Liverpool Hospital Redevelopment - Stage 2

Infrastructure and Ancillary Hospital Works

Preferred Project Report Addendum

Liverpool Hospital Redevelopment
Stage 2 Infrastructure and Ancillary Hospital Works
(MP08_0062)

Figure 6. Detail of new works to Hart Street and Intersection with the Hume Highway

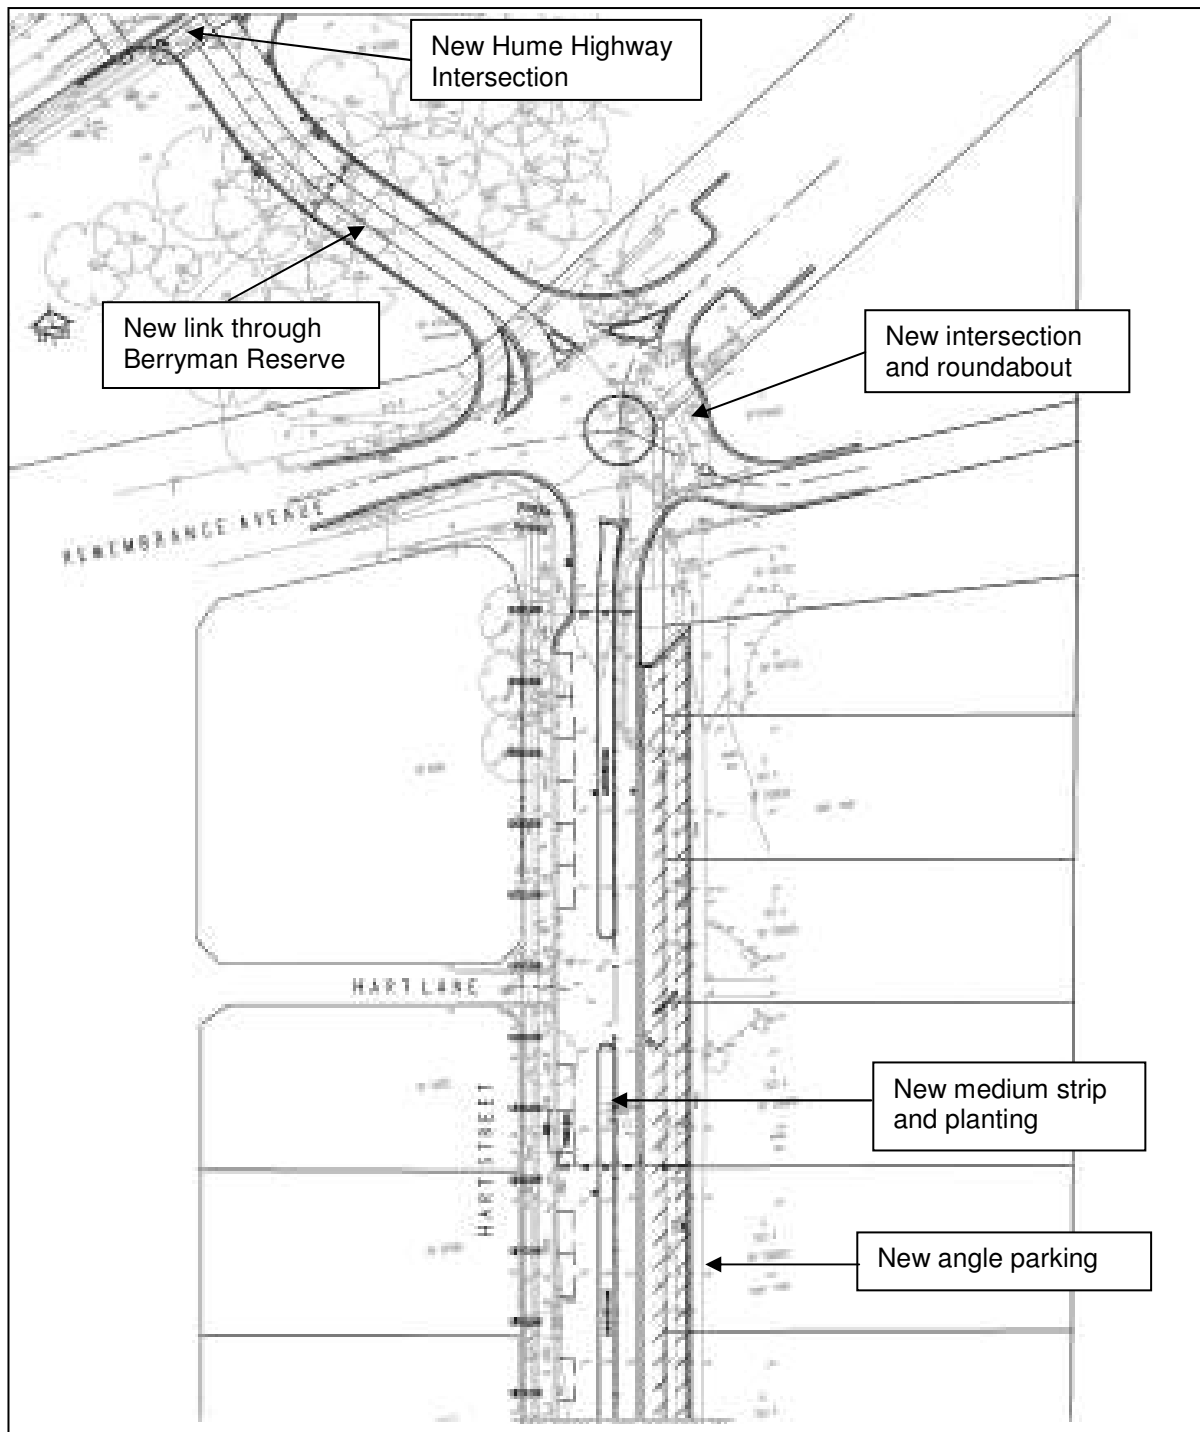
3. The proposed new intersection at Hume Highway and extension of Hart Street shall be designed to meet RTA's requirements and endorsed by a suitably qualified Chartered Engineer (i.e. who is registered with the Institute of Engineers, Australia). The design requirements shall generally be in accordance with the RTA's Road Design Guide and other Australian Codes of Practice. Certified copies of the civil design plans are to be submitted to the RTA for consideration and approval prior to the commencement of road works.

The new intersection is to provide:

- i) a left turn slip lane in accordance with current RTA Road Design Guidelines for westbound traffic turning from Hume Highway into the new road extension from Hart Street
- ii) a right turn lane of at least 100 metres length on Hume Highway for eastbound traffic turning into the new road extension from Hart Street.

4. A Design Road Safety Audit is to be undertaken for the proposed new intersection of Hume Highway and Hart Street extension and submitted to the RTA for approval. The audit is to be carried out by an independent Level 3 Accredited Road Safety Auditor. The audit is to provide specific comment on the merging of traffic either side of the proposed new intersection.

5. The provision of the deceleration lane may require land to be dedicated as public road, which shall be at no cost to the RTA and Council.
6. The intersection of Remembrance Avenue and Hart Street is to be redesigned to provide a four-way, priority controlled, intersection. Priority is to be given to through traffic on Hart Street and the new road extension. In this regard it will be necessary to relocate/redirect the fifth access road from the commuter car park away from the four-way intersection.

<p>3. The proposed new intersection at Hume Highway and extension of Hart Street shall be designed to meet RTA's requirements and endorsed by a suitably qualified Chartered Engineer (ie who is registered with the Institute of Engineers, Australia). The design requirements shall generally be in accordance with the RTA's Road Design Guide and other Australian Codes of Practice. Certified copies of the civil design plans are to be submitted to the RTA for consideration and approval prior to the commencement of road works.</p> <p>The new intersection is to provide:</p> <ul style="list-style-type: none"> i) a left turn slip lane in accordance with current RTA Road Design Guidelines for westbound traffic turning from Hume Highway into the new road extension from Hart Street. ii) a right turn lane of at least 100 metres length on Hume Highway for eastbound traffic turning into the new road extension from Hart Street. <p>RTA fees for administration, plan checking, civil works inspections and project management shall be paid by the developer prior to the commencement of works.</p> <p>The developer may be required to enter into a Works Authorisation Deed (WAD) for the abovementioned works. Please note that the Works Authorisation Deed (WAD) may need to be executed prior to the RTA's assessment of the detailed civil design plans.</p>	<p>Noted.</p> <p>Noted.</p> <p>Noted.</p> <p>Noted.</p>

4. A Design Road Safety Audit is to be undertaken for the proposed new intersection of Hume Highway and Hart Street extension and submitted to the RTA for approval. The audit is to be carried out by an independent Level 3 Accredited Road Safety Auditor. The audit is to provide specific comment on the merging of traffic either side of the proposed new intersection.	Noted.

5. The provision of the deceleration lane may require land to be dedicated as public road, which shall be at no cost to the RTA and Council.	Noted.
